Our ref: Residential flat building with in-fill affordable housing – 5–9 Cowan Road, St Ives (SSD-88948458)

Subject: Response to Submissions

ATTACHMENT A – ITEMS TO BE ADDRESSED

Figure 7-1 Truck Approach and Departure Route

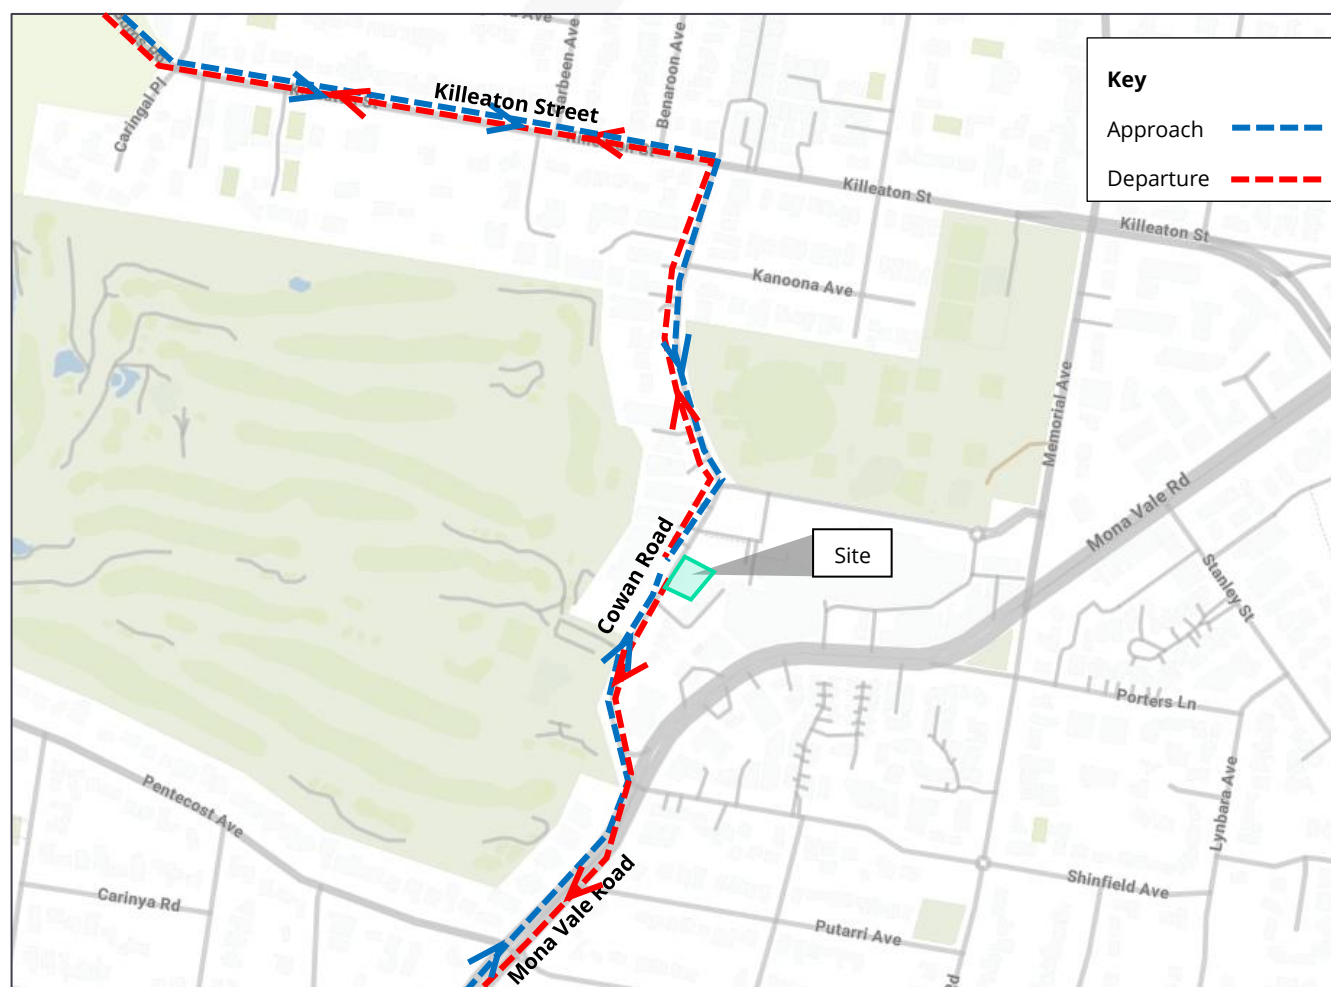
27. Ensure any variations to the ADG design criteria are all clearly identified and justification provided.
28. Review the proposed construction route, noting Killeaton Street is a load-limited route meaning use by heavy vehicles which do not have an origin or destination within the area is prohibited. The topography, amenity impacts and other constraints also appear to make the proposed Killeaton Street route inappropriate for construction vehicles.

DRAWING TITLE:
Ground floor plan

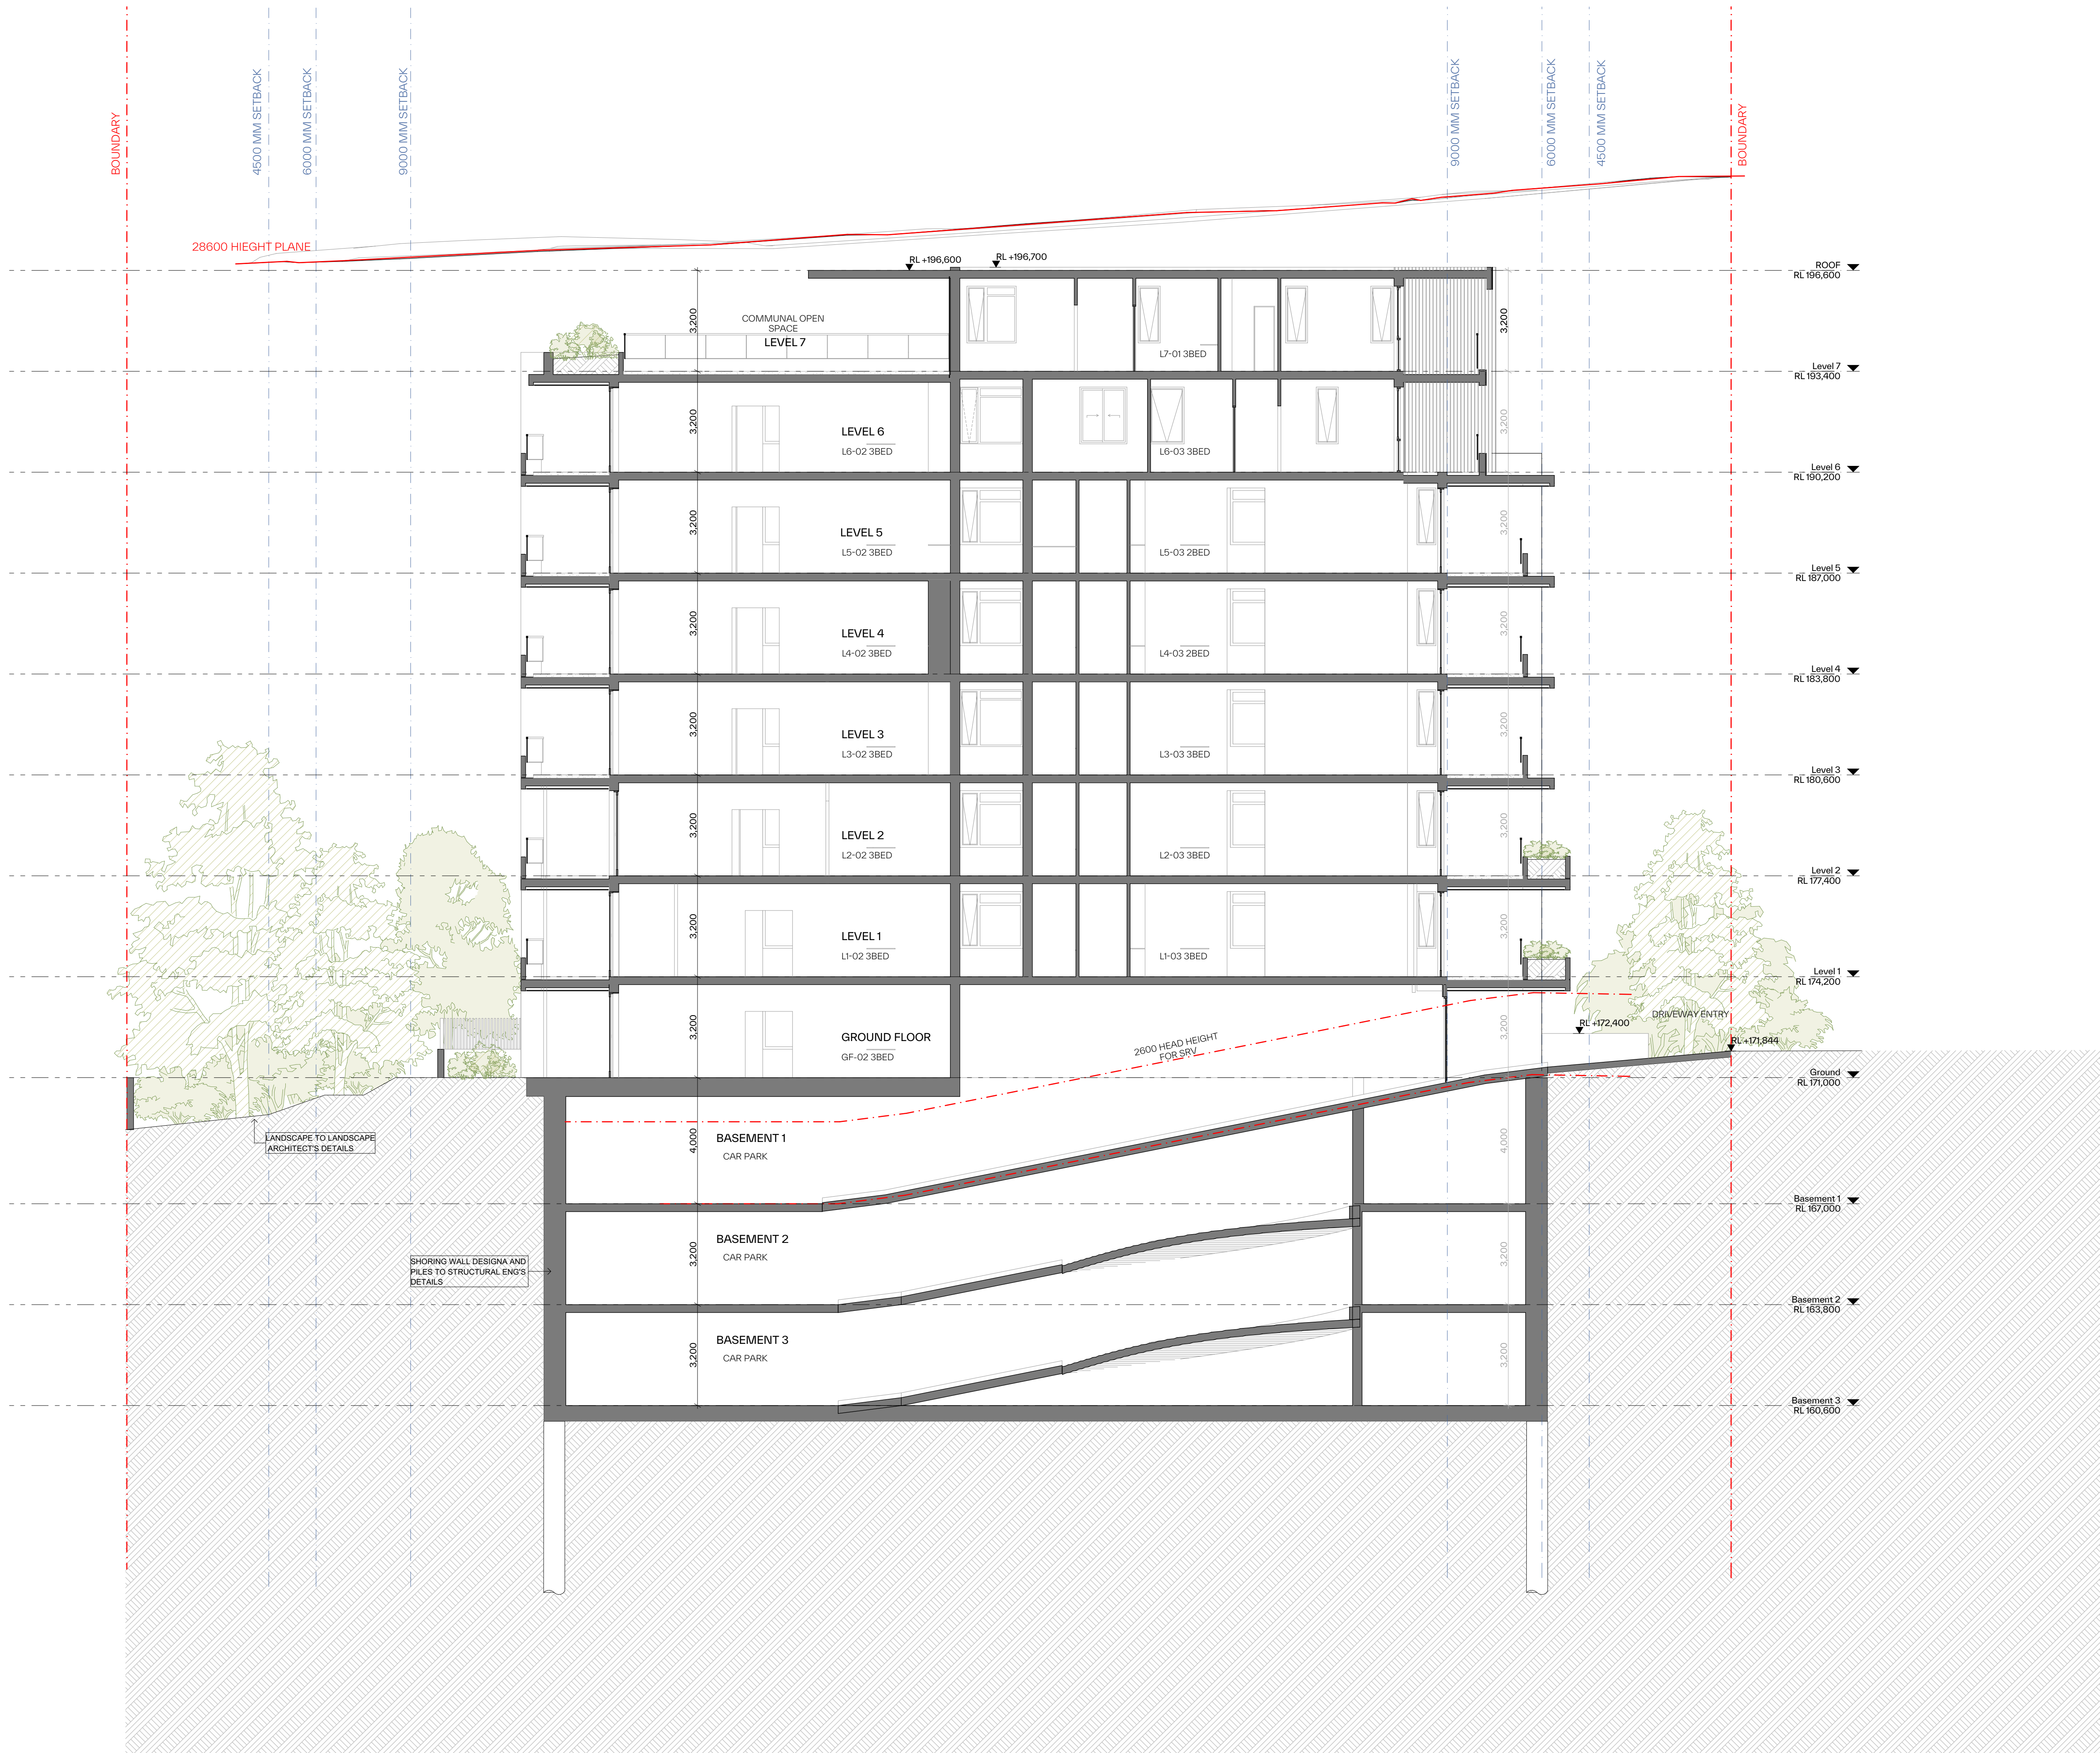
4. Review the GFA calculation plan, noting 14.9% of the overall GFA appears to be dedicated to affordable housing GFA rather than the required 15% and some areas appear to be incorrectly calculated, including:
 - the external area to GF-05
 - the voids to level 9 (DA110).

Landscape Strategies

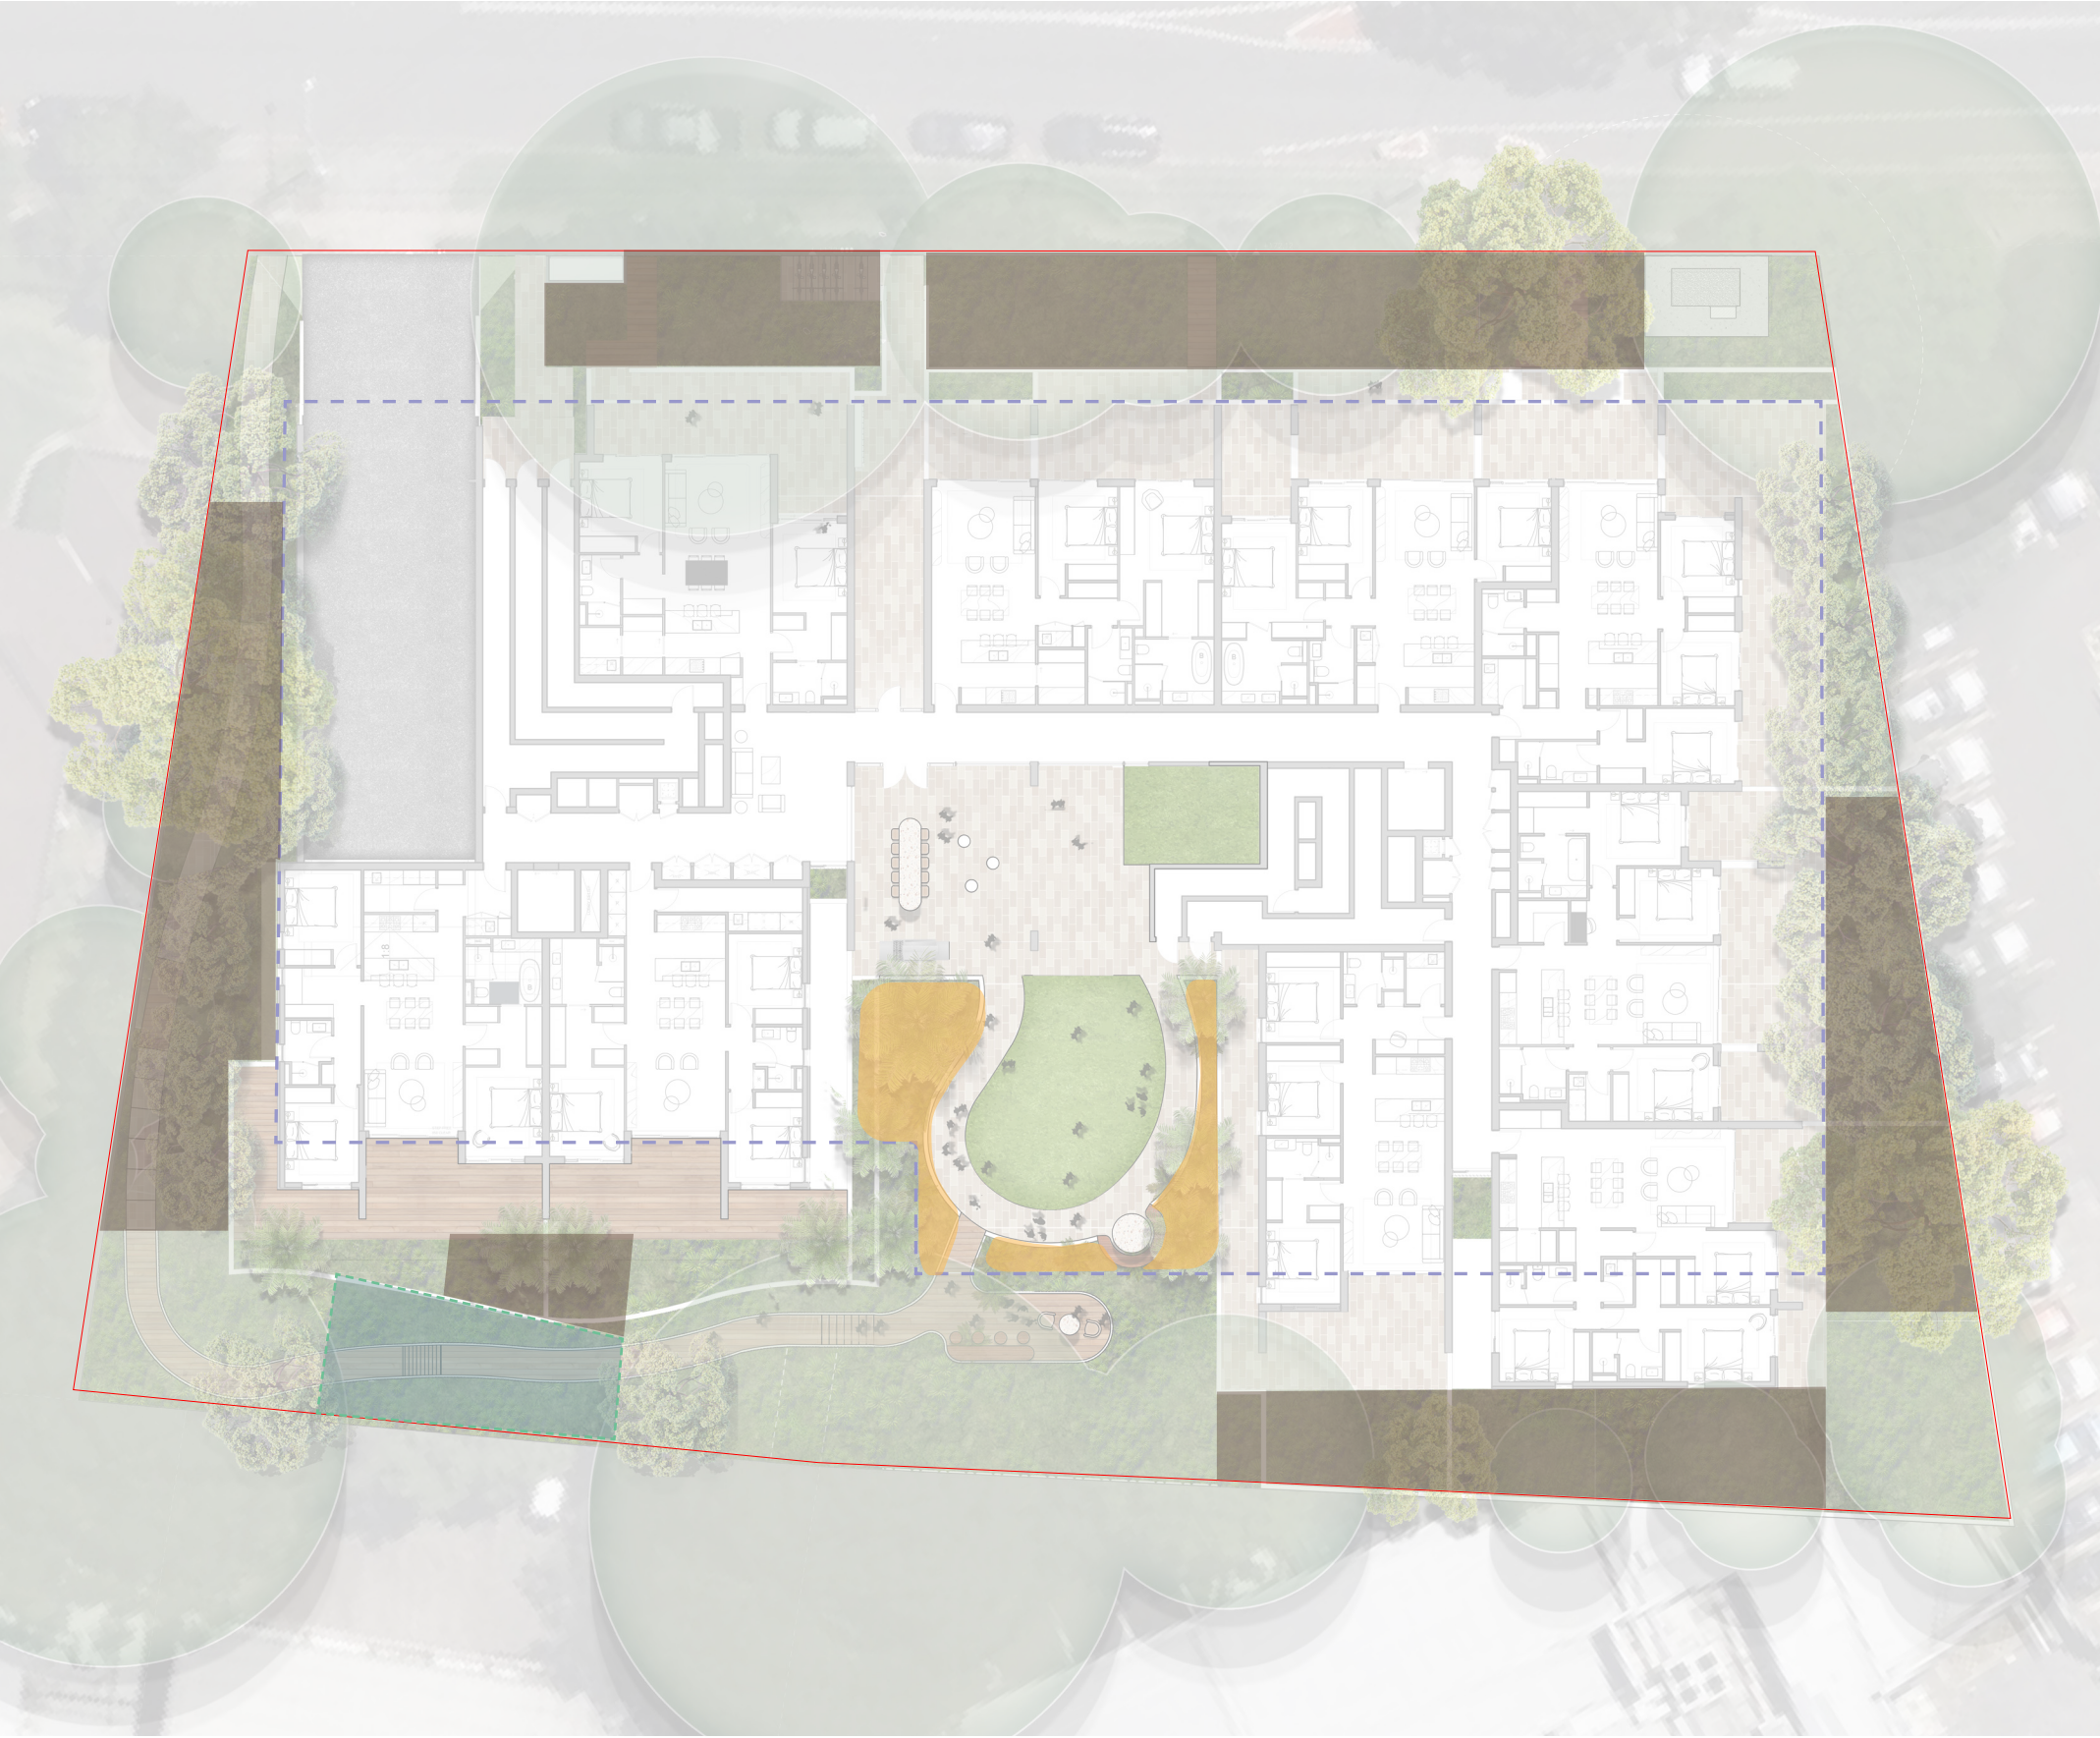
15. Revise the level 8 communal open space calculation plan (DA540) as it has included the area beyond the balustrading, which is not accessible.
16. Revise the deep soil calculation plan to show dimensions of 6 m and an area of no less than 7% of the site area as per the design criteria contained in part 3E of the ADG.
17. Revise the landscaped area calculation plan to exclude any footpaths or other hard surfaced areas, as this is not counted as landscaped area.
18. Revise the ground floor architectural plans against the landscape plan, as there is inconsistency between the location of paving, decking and landscaped area.

Tree Removal and Replacement Plan

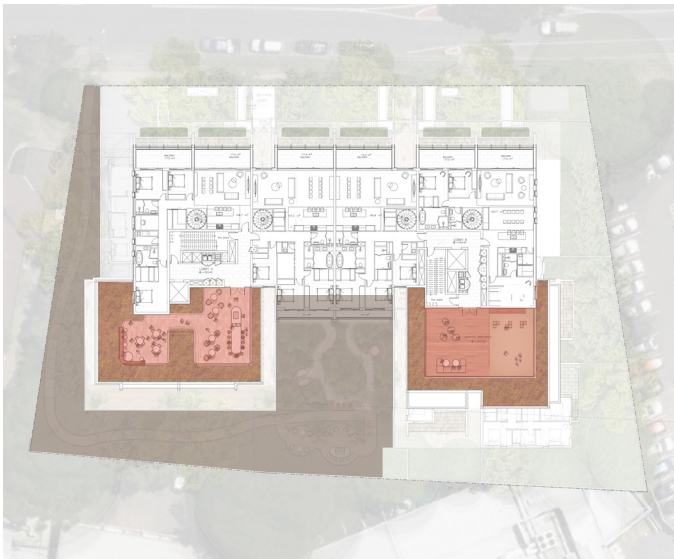
5. Revise the development to retain trees 2, 15, 16, 18, 19 and 24, as these trees significantly contribute to the streetscape. In addition, update the arborist report to:
